# CITY OF ALBUQUERQUE

**Re: Gillani Residence, Grading and Drainage Plan  
Lot 10, Block 1, Tract 3, Unit 3, NAA  
8800 Modesto Ave., NE  
Engineer's Stamp dated 11-02-13 (C20/D068)**

October 31, 2013

**Re: Gillani Residence, Grading and Drainage Plan  
Lot 10, Block 1, Tract 3, Unit 3, NAA  
8800 Modesto Ave., NE  
Engineer's Stamp dated 9-30-13 (C20/D068)**

GRADING & DRAINAGE PLAN

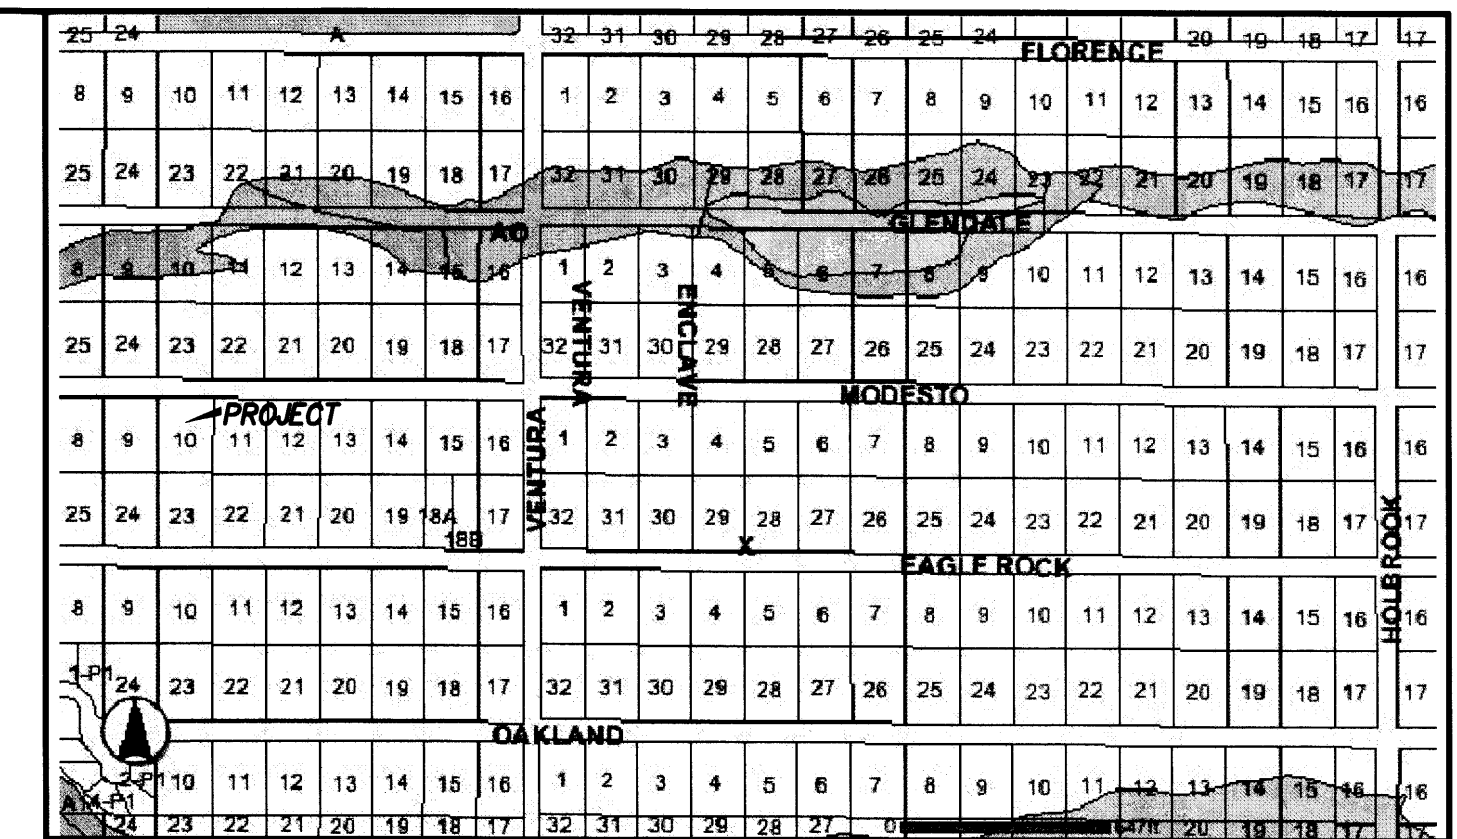
- The contractors in most cases grade/disturb the entire lot. Therefore, under developed conditions land treatment A should be zero. Please also double check land Treatment D.
- Provide an offsite basin map. How much runoff will be draining through the 18" CMP proposed in the road?
- Provide culvert capacity calculations for all the pipes. Is the swale north side of the property sized adequately to carry the offsite runoff from the east?
- Provide detail elevations for the entrances and the culvert crossing. Please include edge of the asphalt along Modesto and top of culvert elevations.
- Provide riprap at the outlet of the pipes.

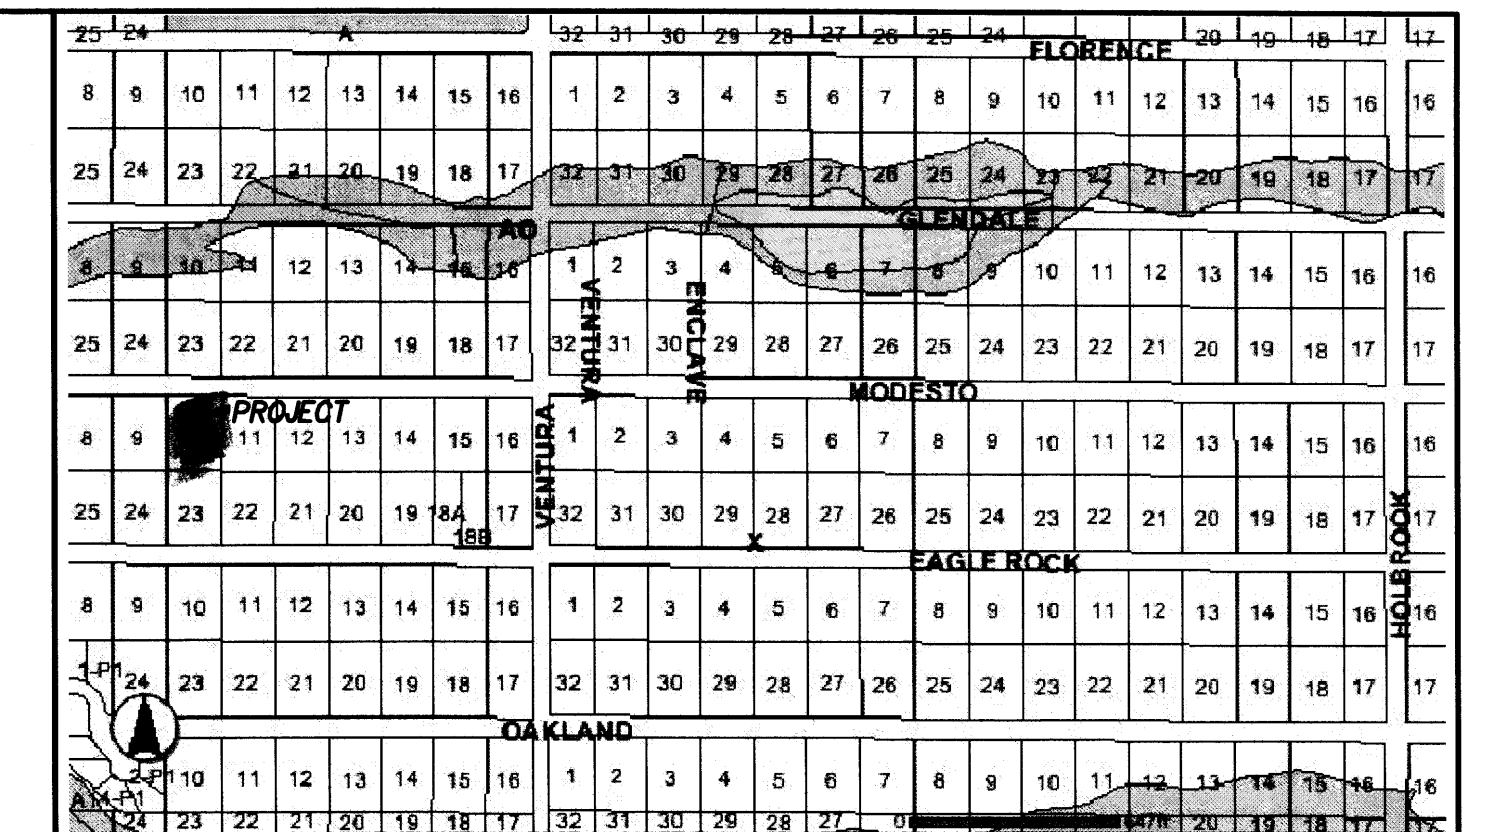
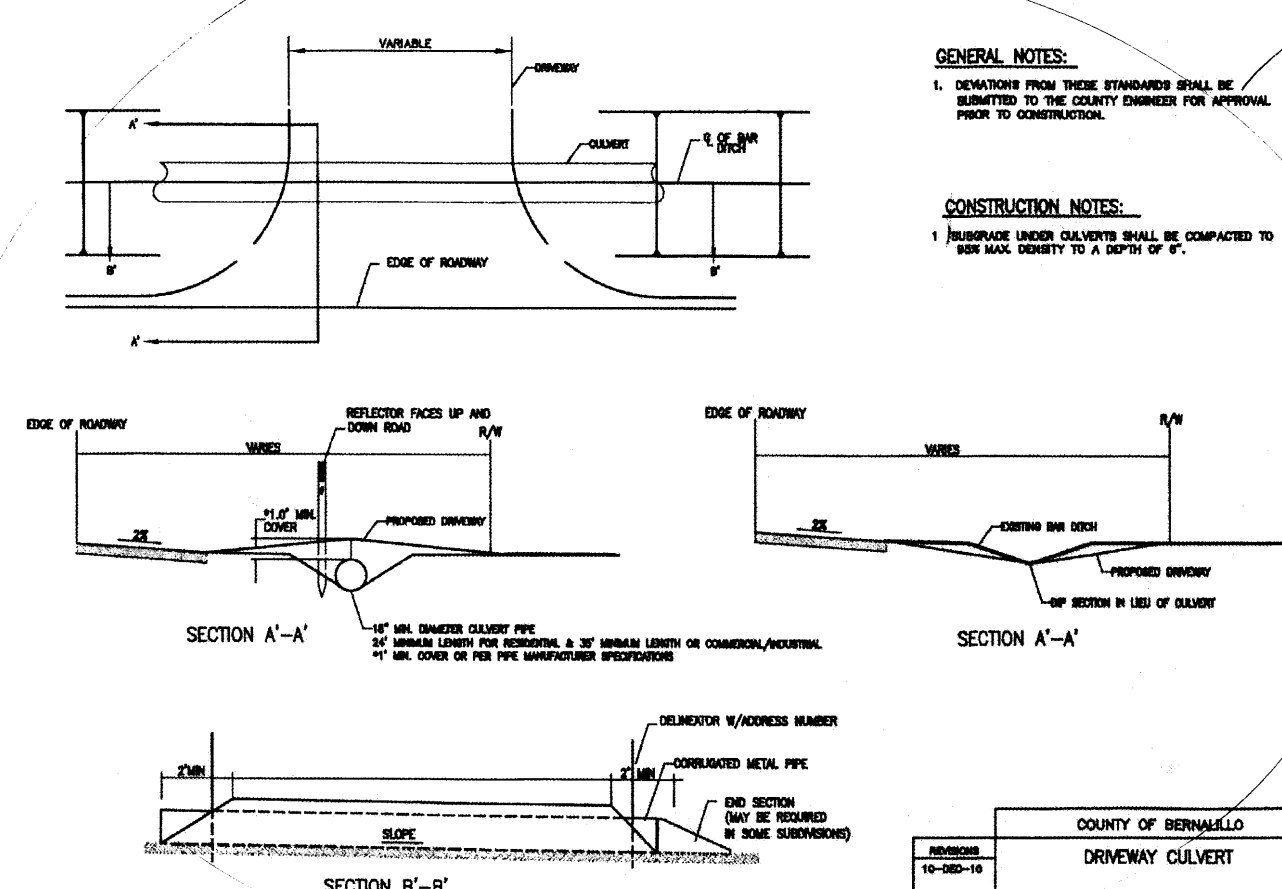
Based upon the information provided in your submittal received 10-03-13, the above referenced Grading and Drainage Plan cannot be approved for building permit based on the following comments:

- Carry the offsite runoff from southeasterly portion of the lot to the north to Modesto in a swale and avoid building additional culvert and improvement in front of the Garage.
